Ann Ronay  
Unit 110  
141-143 McEvoy Street  
Alexandria  
NSW 2015

29 January 2018

**Re: Development Application SSD 8373 – Alexandria Park Community School Redevelopment, Park Road, Alexandria 2015**

3 WINTER 3PM
1 : 1000

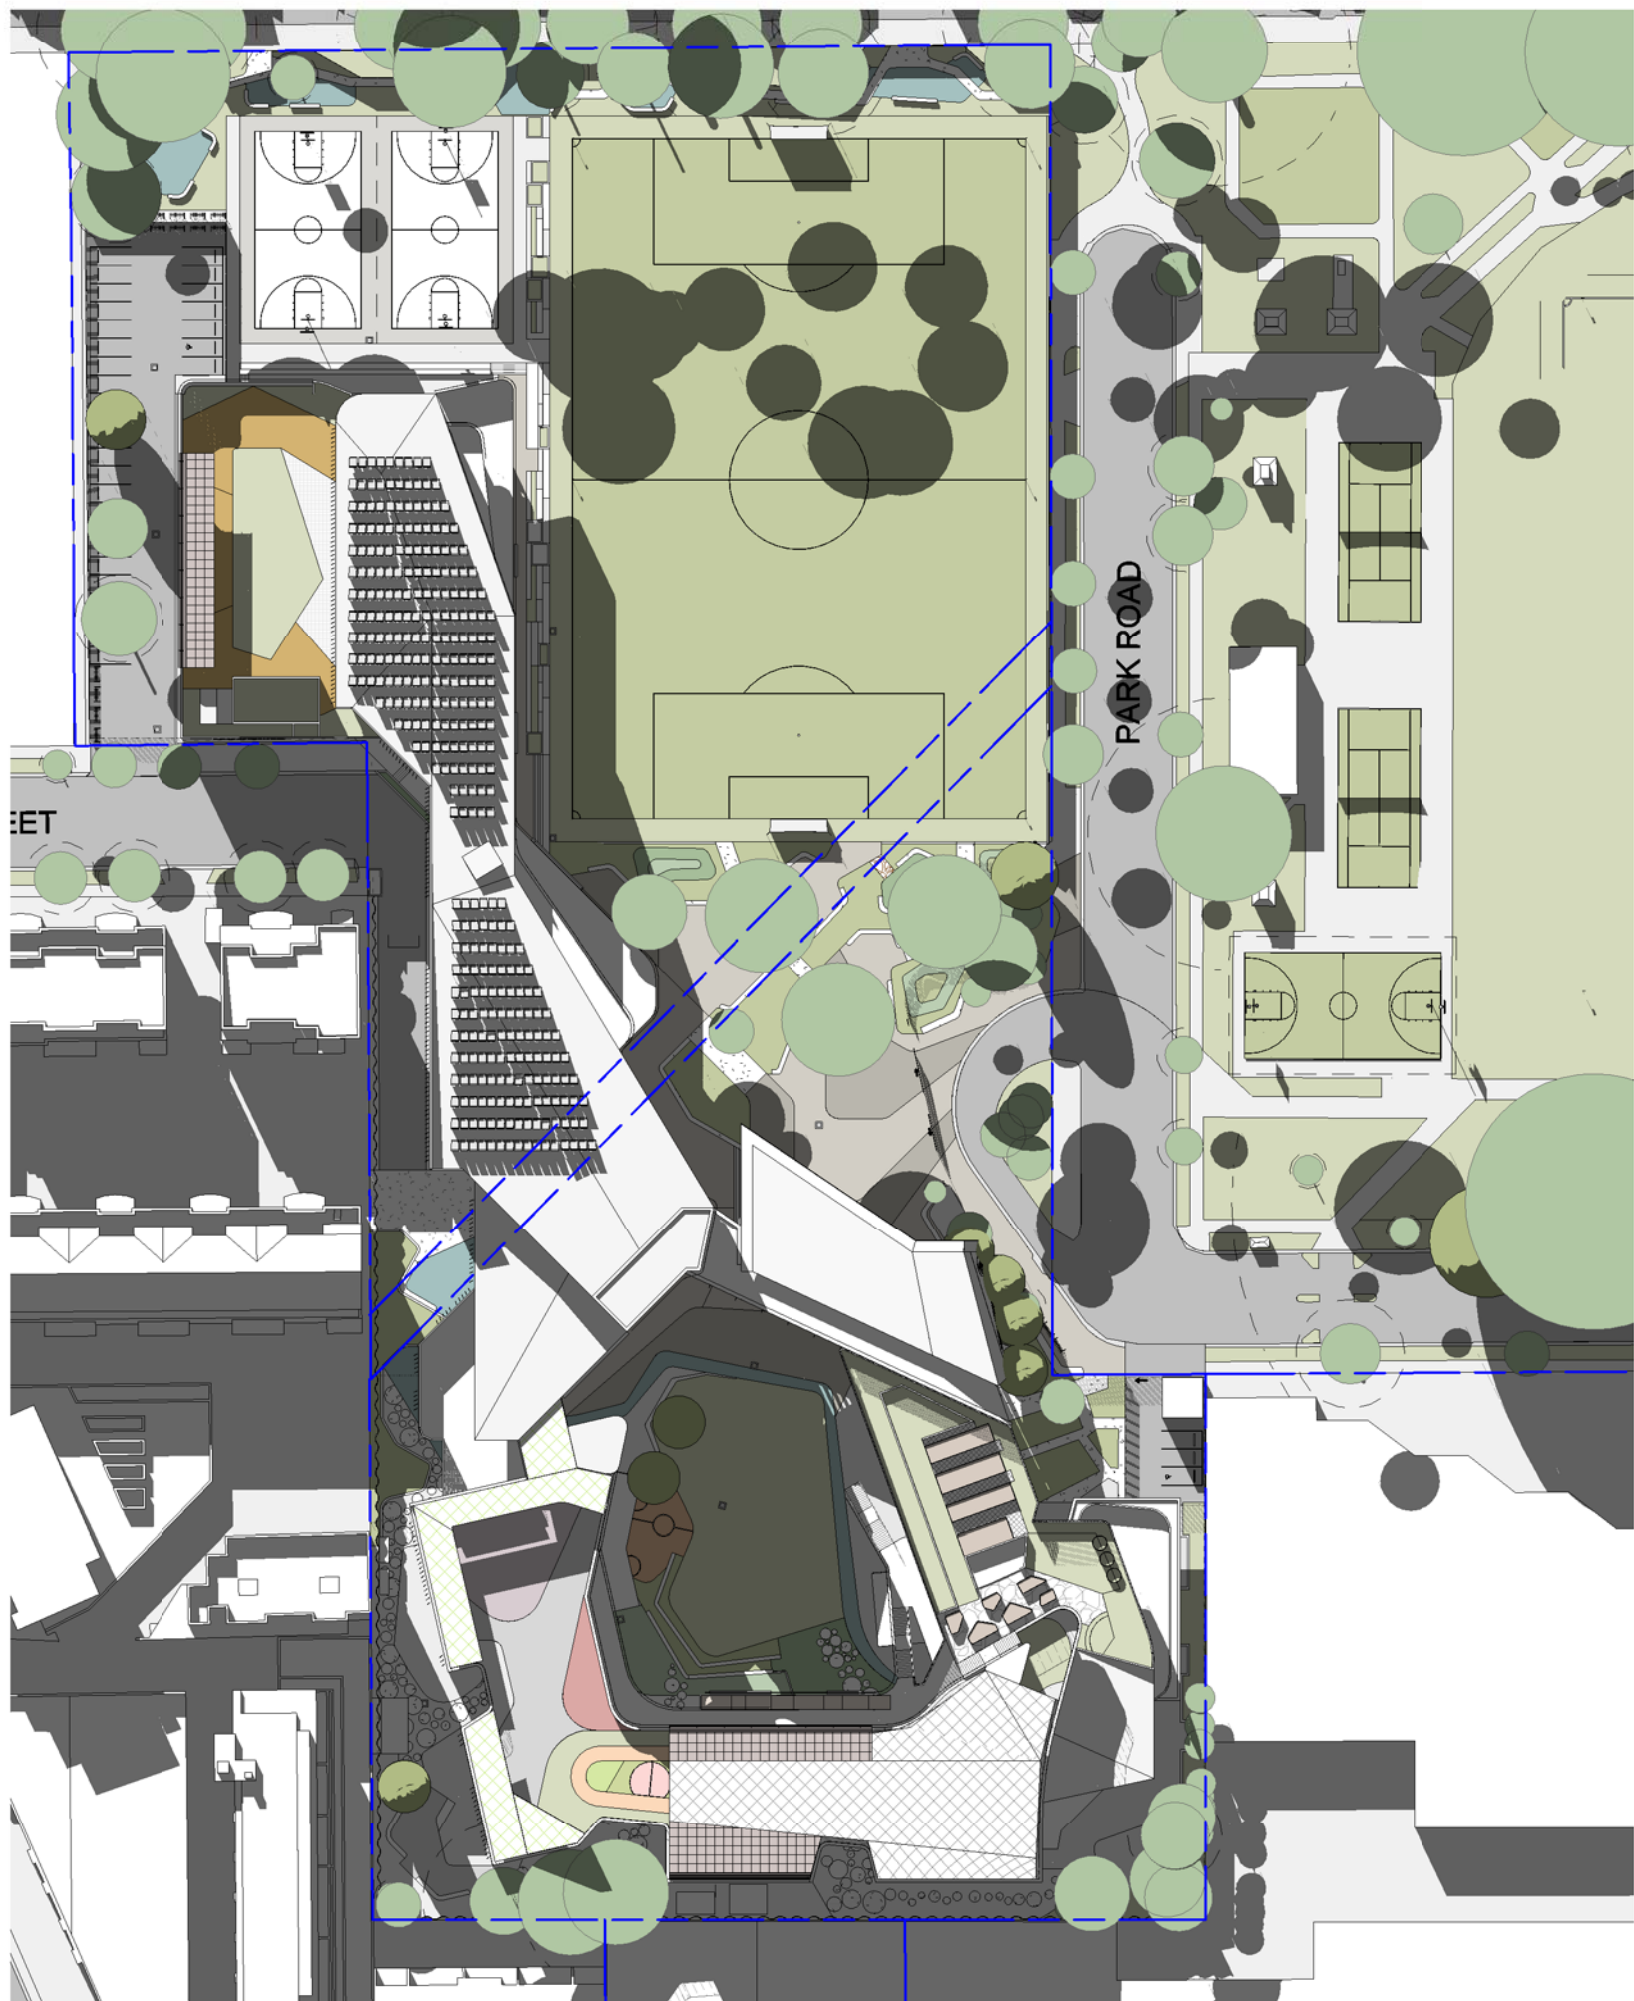
The 15 units in 141-143 McEvoy Street on the southern boundary all have living areas & outdoor areas facing north and the impact on of the overshadowing has not been properly assessed. The documents currently notes the buildings along the south perimeter as commercial which is not correct. There are **no shadow elevational diagrams** at all on Drawing No. AR.DA.5002 P1 for 141-143 McEvoy Street which is a residential property & therefore as my understanding is, is required to be taken into consideration.

The shadow plans show that the southern properties will have all sunlight removed at ground level. Has the lowered level of my property and the 5 adjacent properties been taken into consideration in the assessment?
